CITY OF MERCER ISLAND

November 16, 2018

RE: CAO15-001 and SEP15-001 – MI Treehouse Reasonable Use Exception and SEPA Determination

MI Treehouse, LLC,
 5637 EAST MERCER WAY
 MERCER ISLAND, WA.

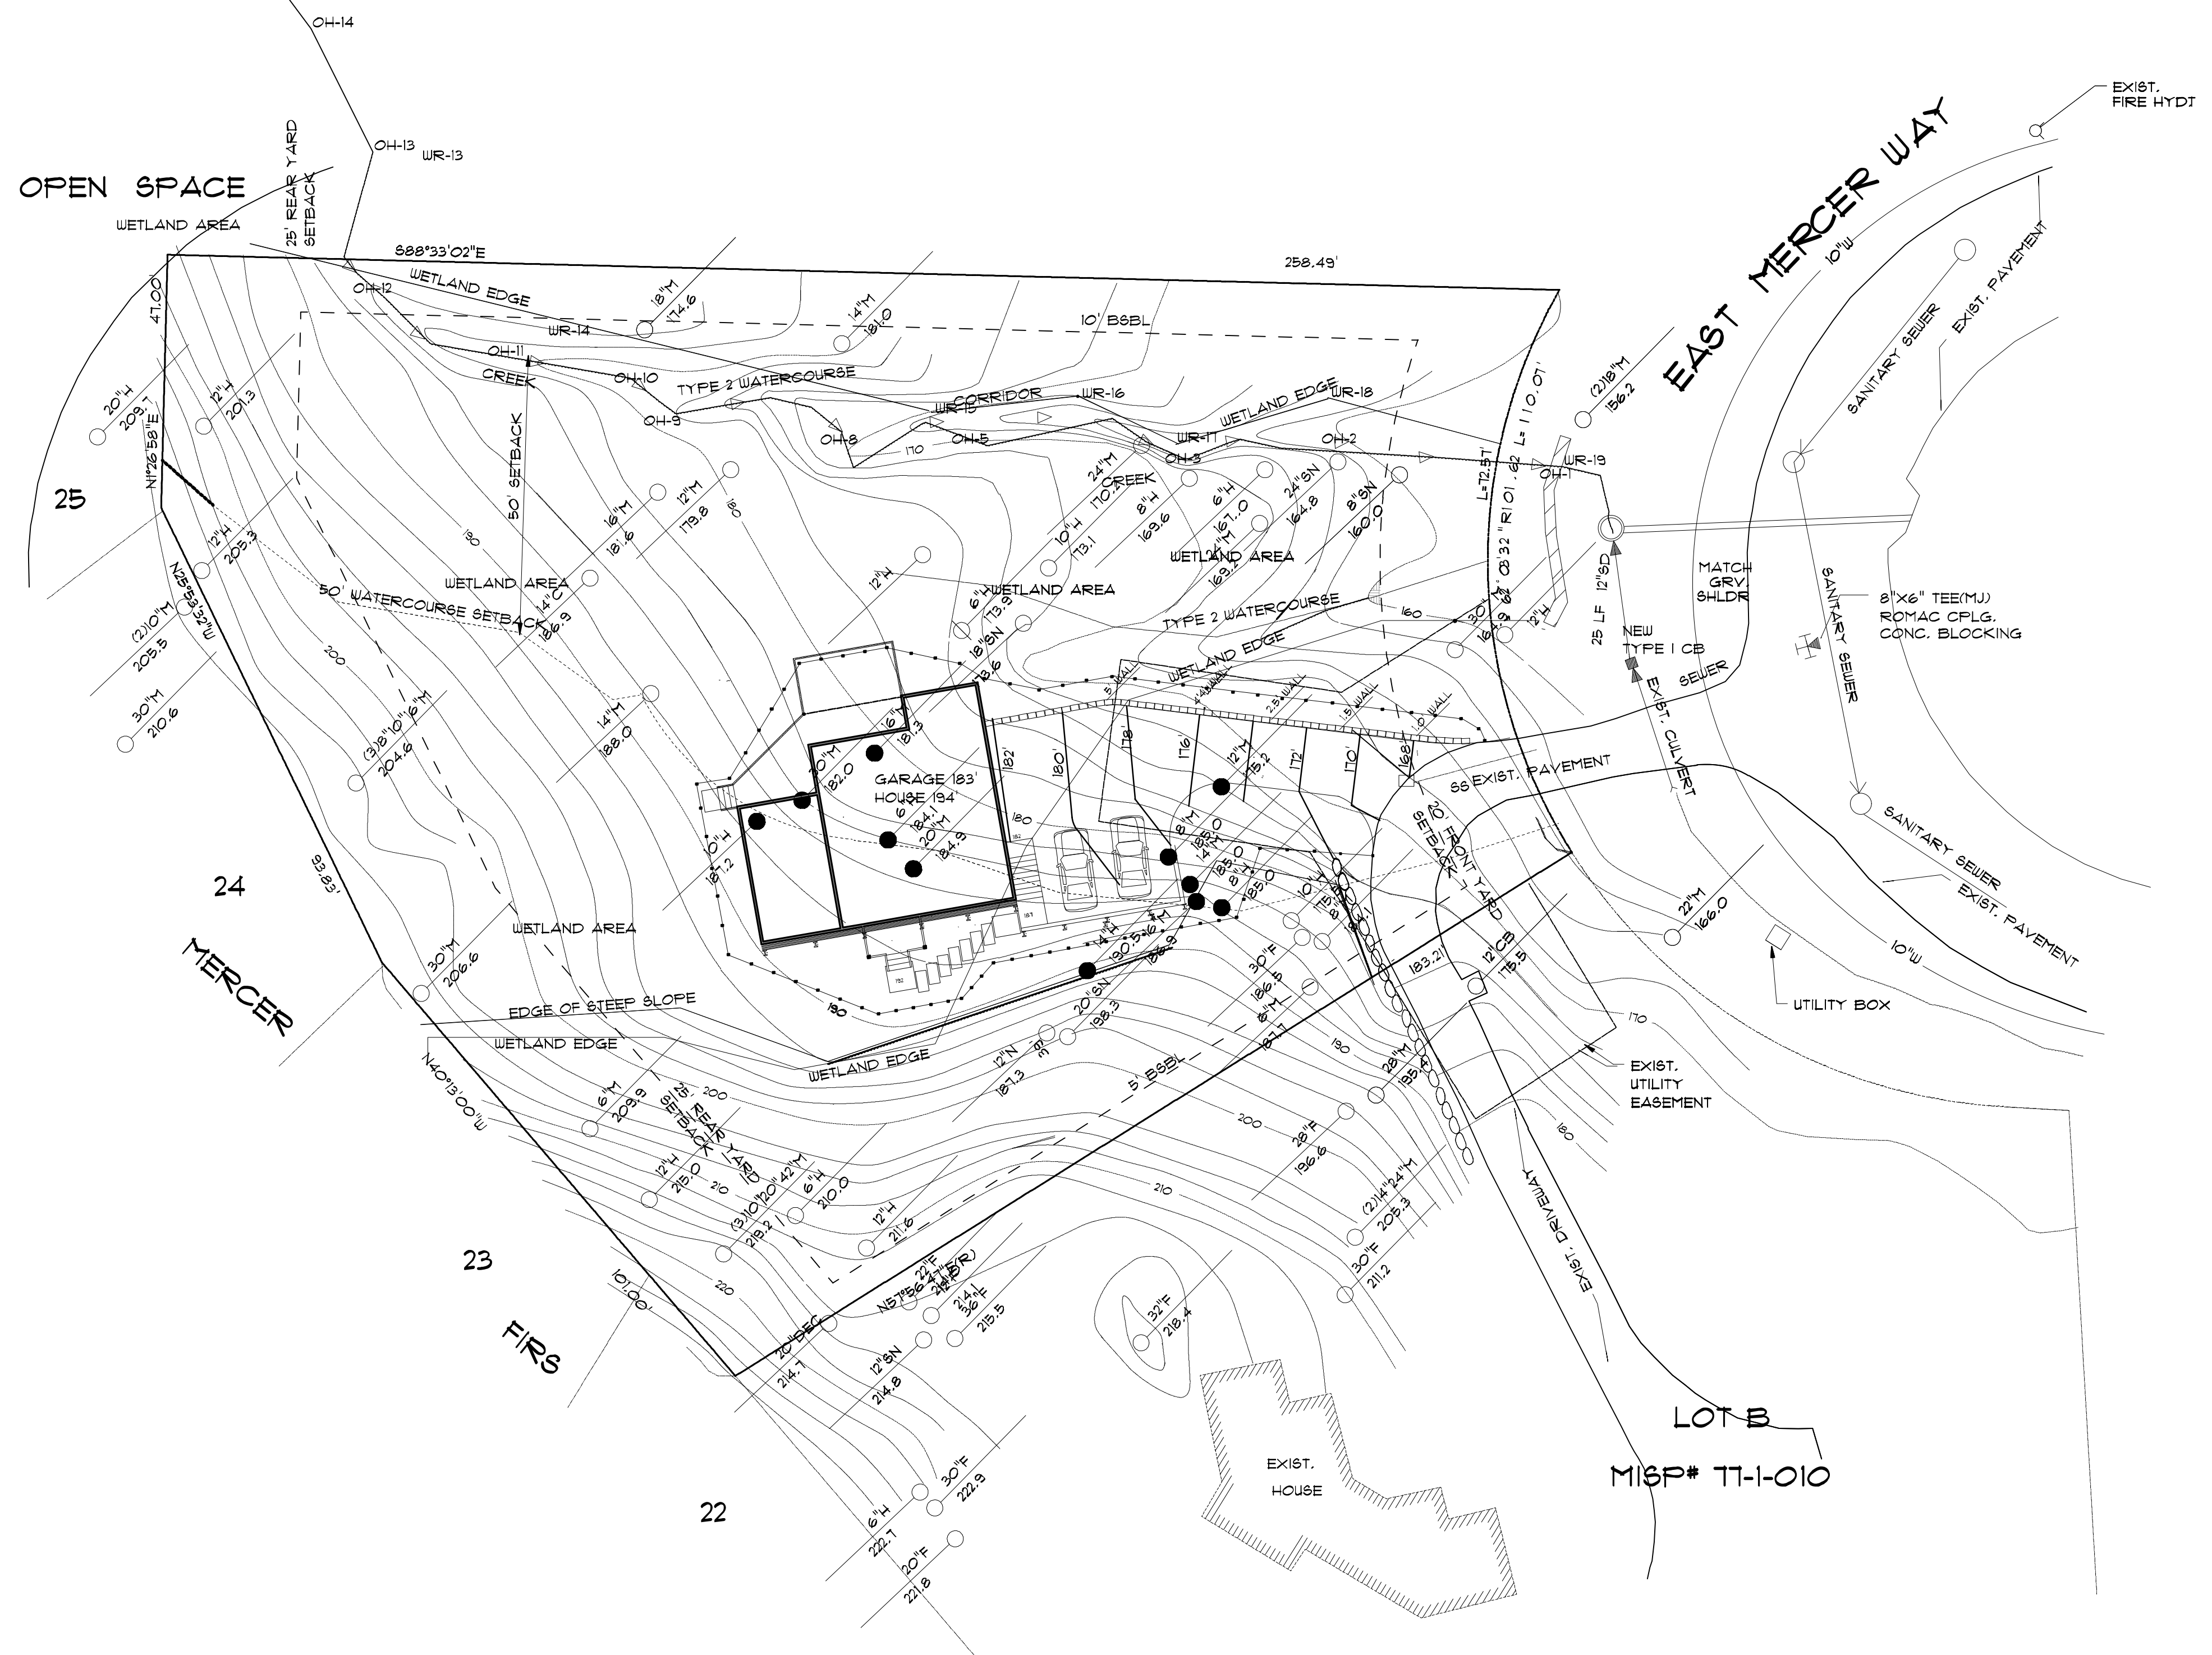
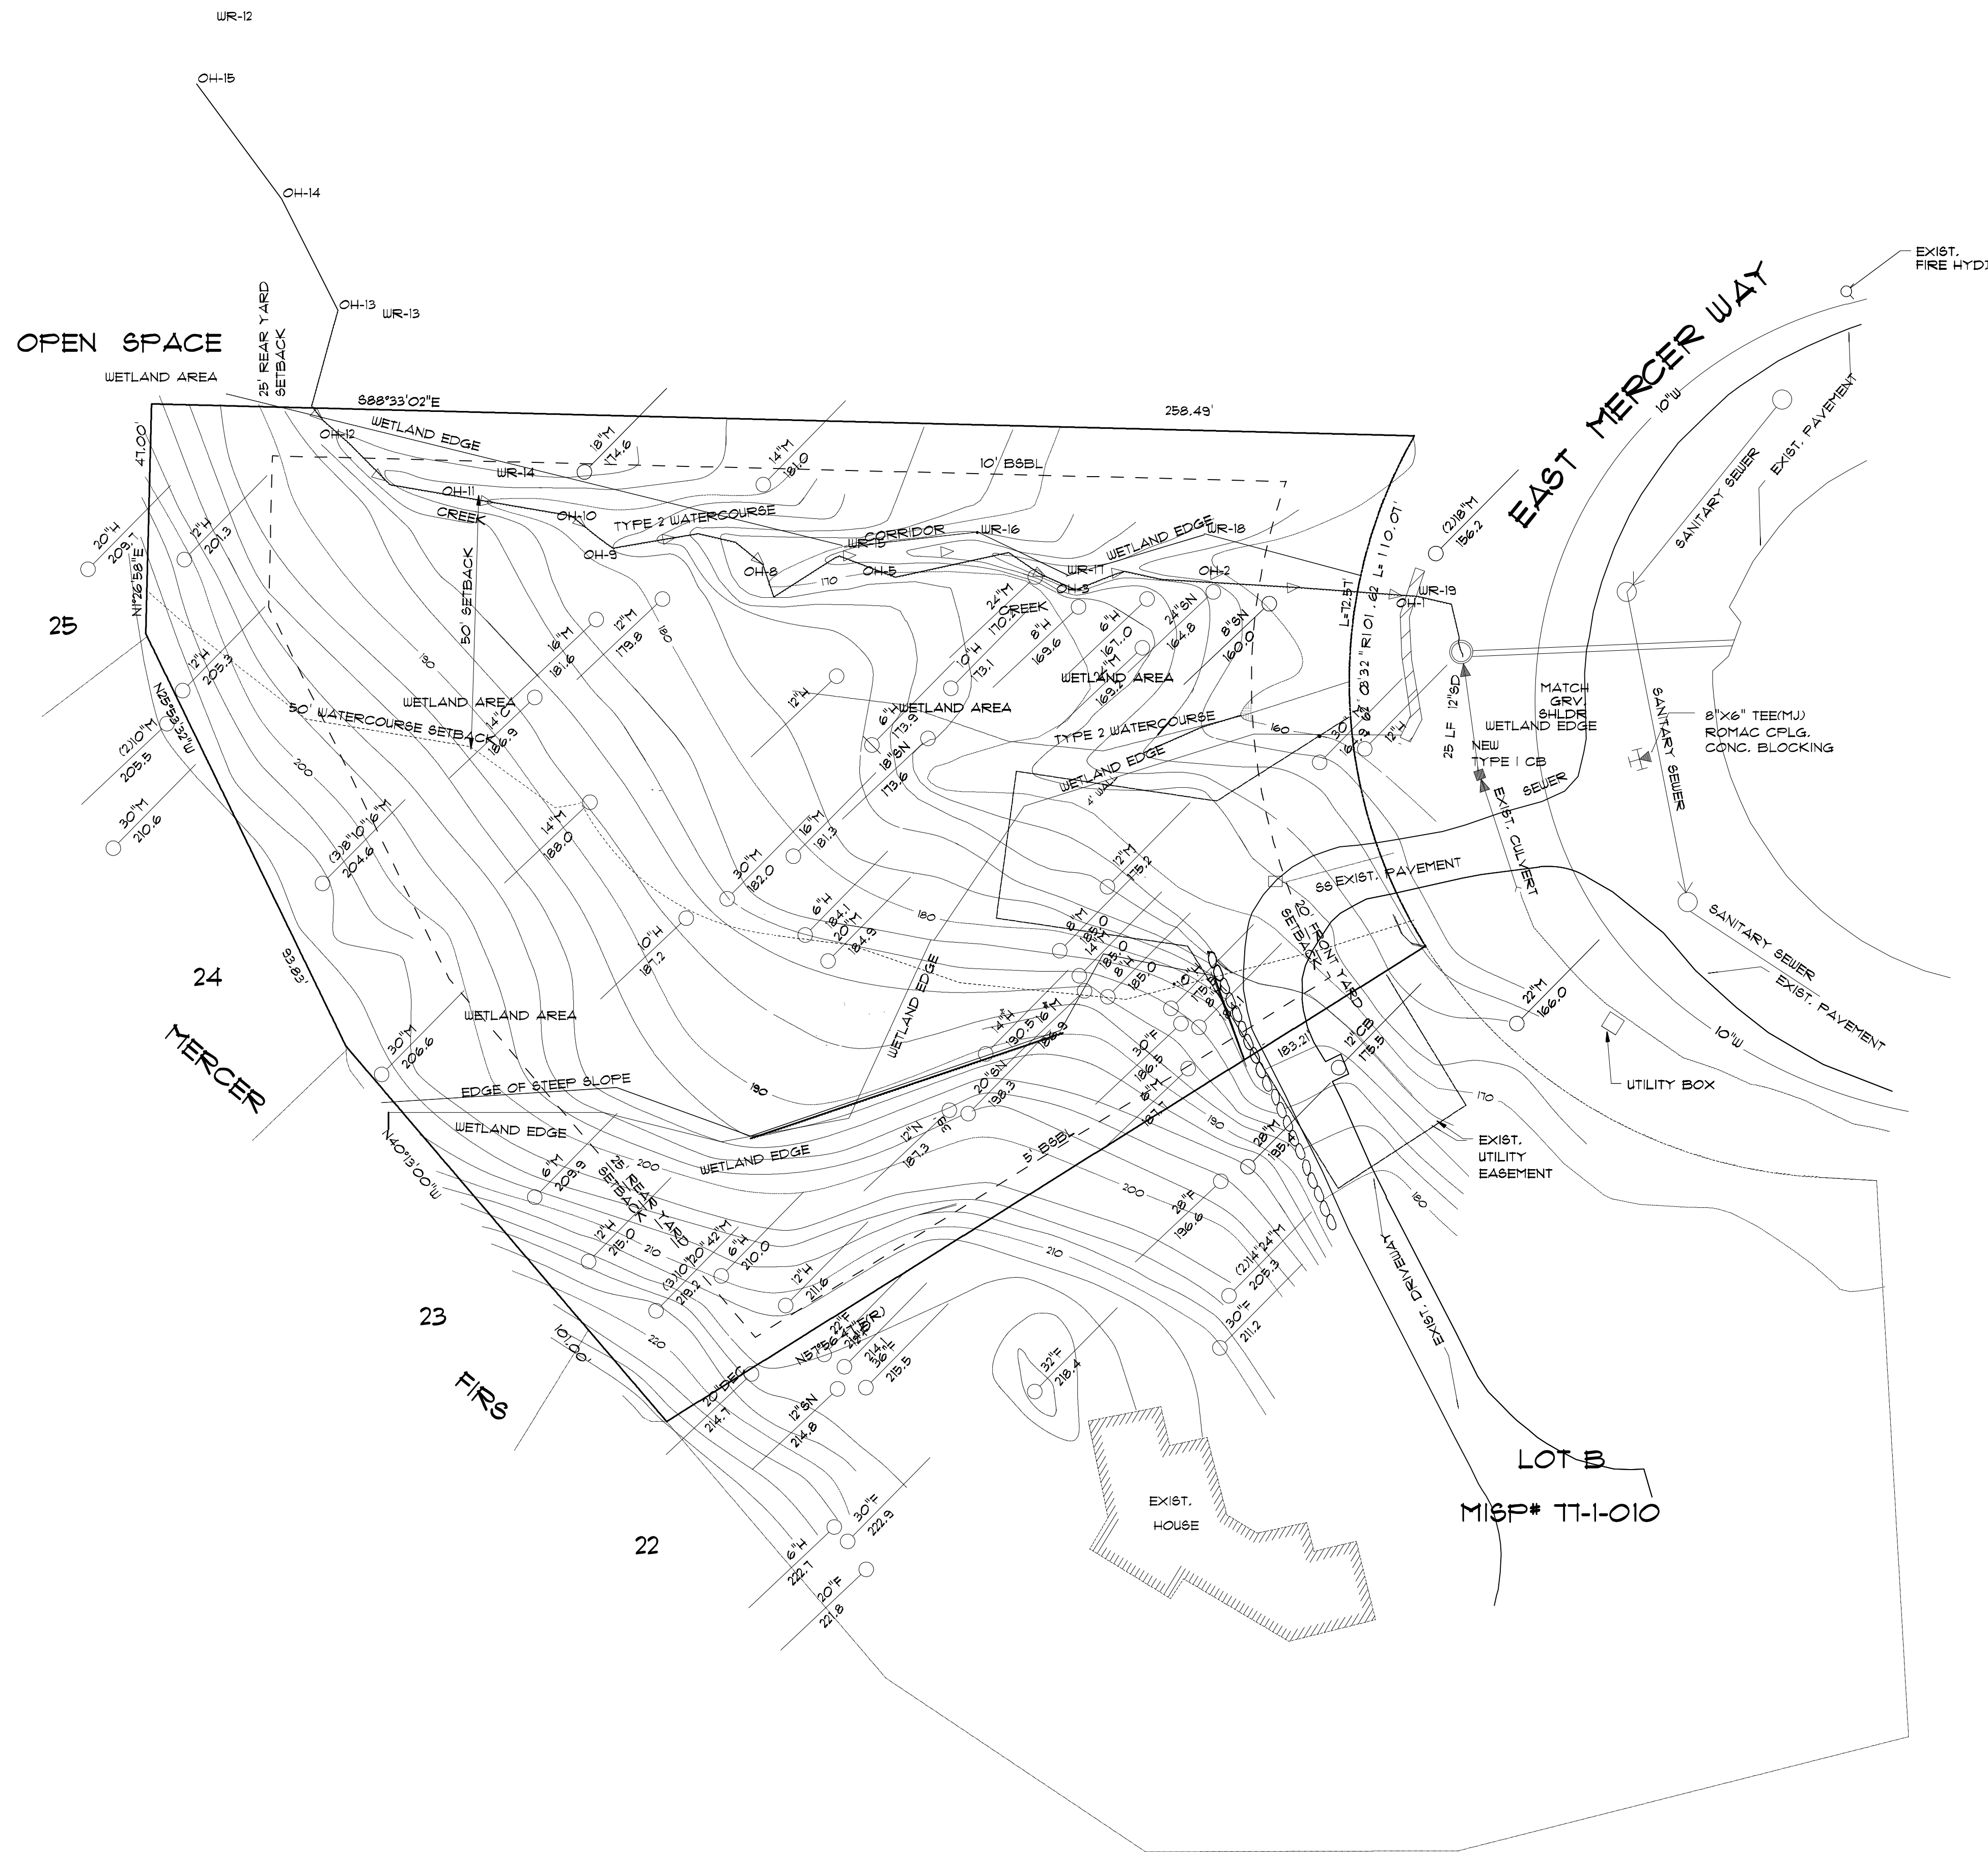
- c. **19.07.030(B)(3)(c):** *Any alteration to critical areas is the minimum necessary to allow for reasonable use of the property.* The Applicant's May 7, 2017 letter indicates that the Applicant is not interested in building the smallest house possible. The March 8, 2018 letter provides additional detail evaluating a mitigation sequencing approach. Neither letter articulates fully how the proposed improvements minimize impacts to multiple critical areas (i.e., the wetland, wetland buffer, and watercourse buffer). For example:
 - Could the house and/or deck footprint be reduced in area to minimize direct wetland disturbance?
 - Is site grading limited to the area immediately adjacent to the house, and if not, would doing so minimize impacts further?

Please revise the application material to address how the proposed site improvements minimize impacts to critical areas.
